CITY OF ALBUQUERQUE

January 8, 2021

**RE: Allaso Vineyards Apartments
Conceptual Drainage Report
Engineer's Stamp Date: No Engineer's Stamp Date
Hydrology File: C20D086**

Based upon the information provided in your submittal received 12/16/2020, the Conceptual Drainage Report is approved for action by the DRB on Site Plan for Building Permit.

Sheet C-101

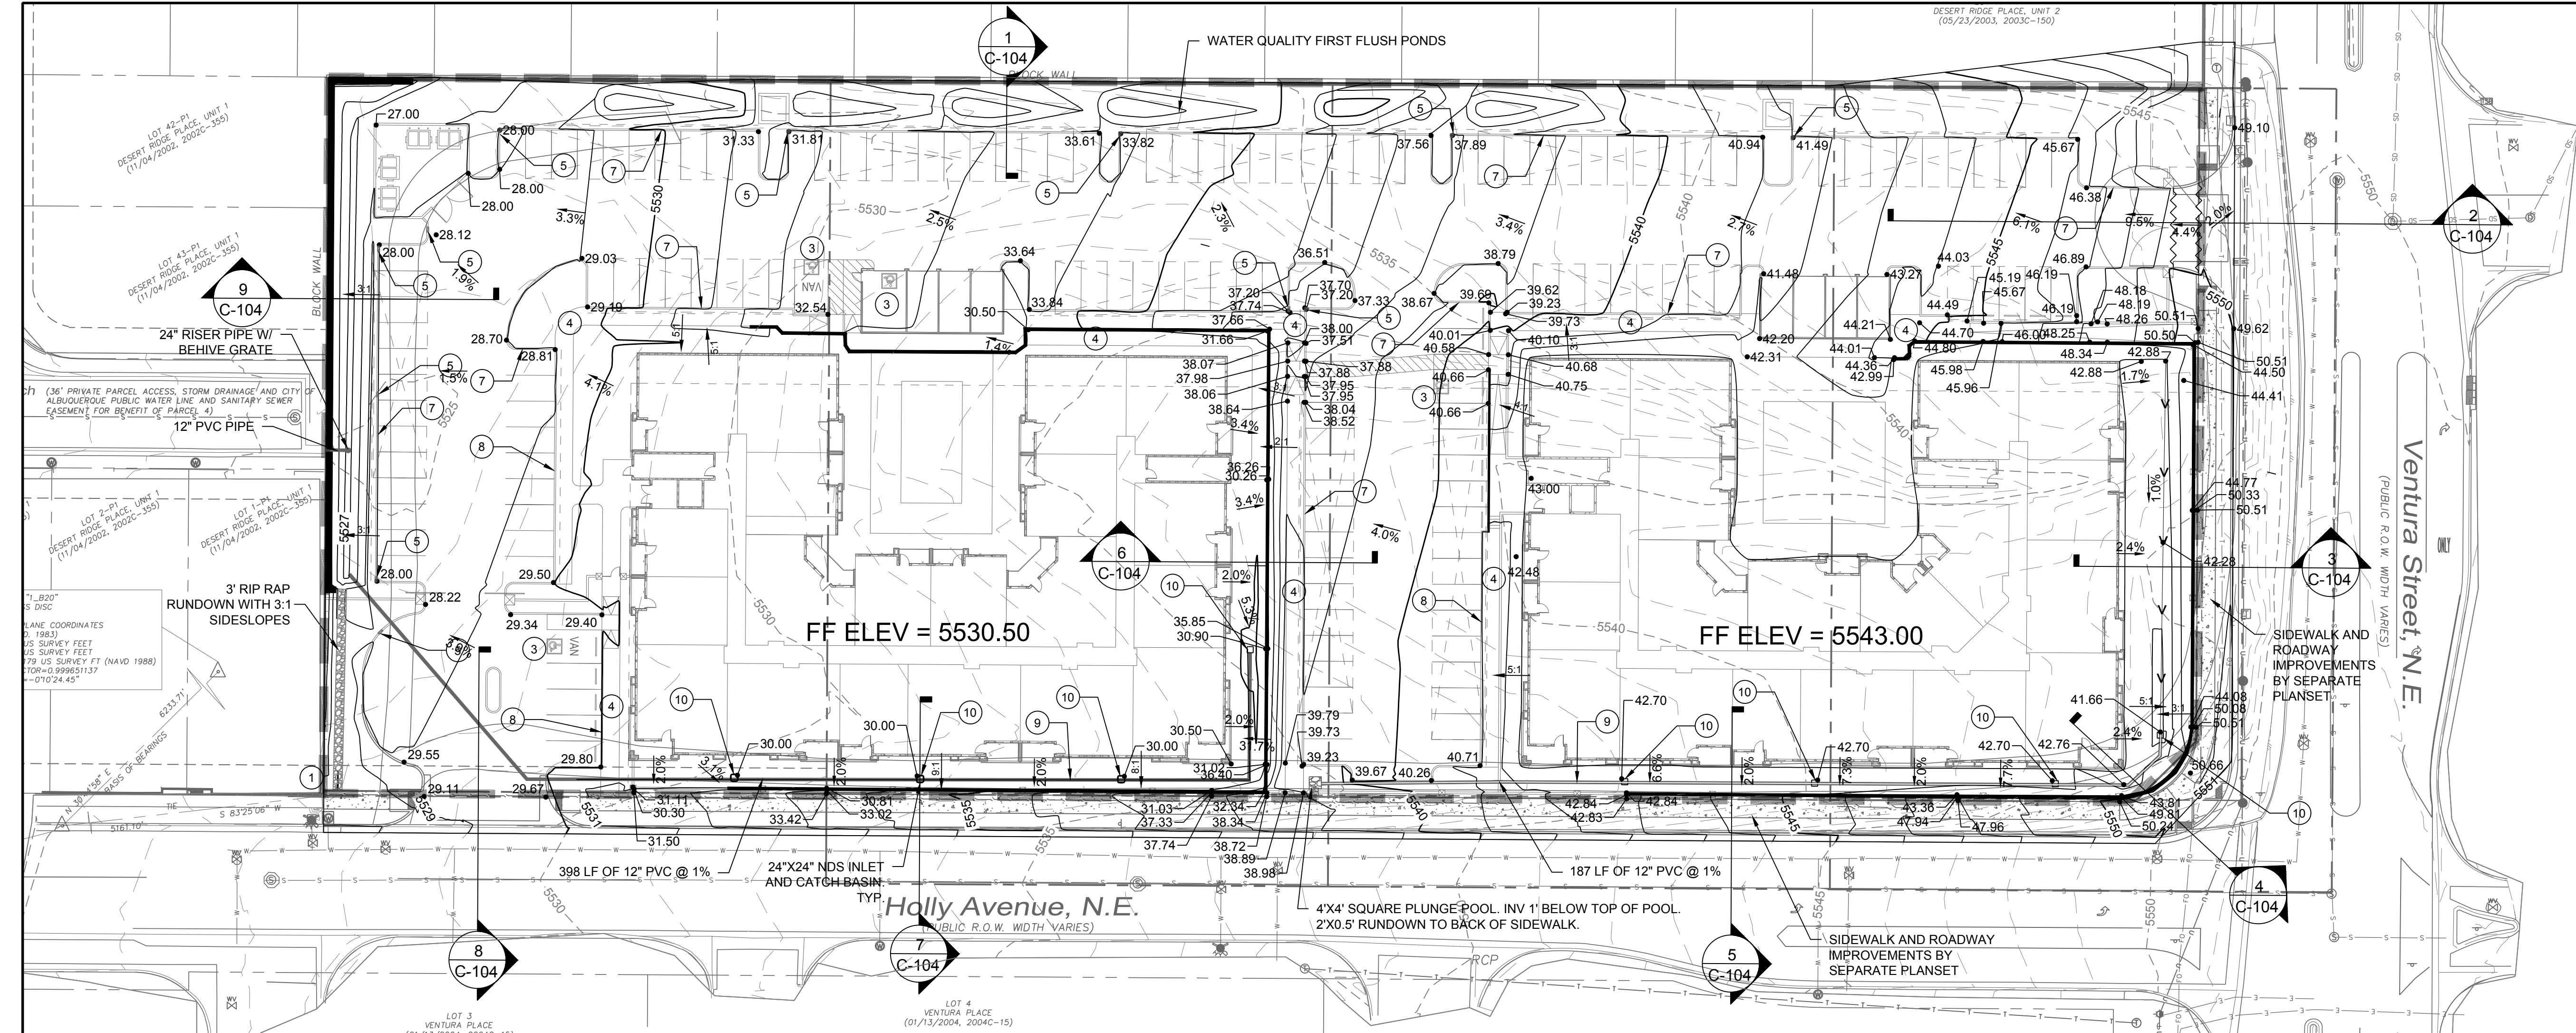
1. Stormwater discharges across the sidewalk are not allowed on collector roads and above; provide sidewalk culverts or drain lines through the curb. (See below)

- Please show in more detail as how the proposed 12" PVC will be outfall into the existing mountable curb runoff (see below). A section showing the riser pipe with all needed elevations may be of some help.
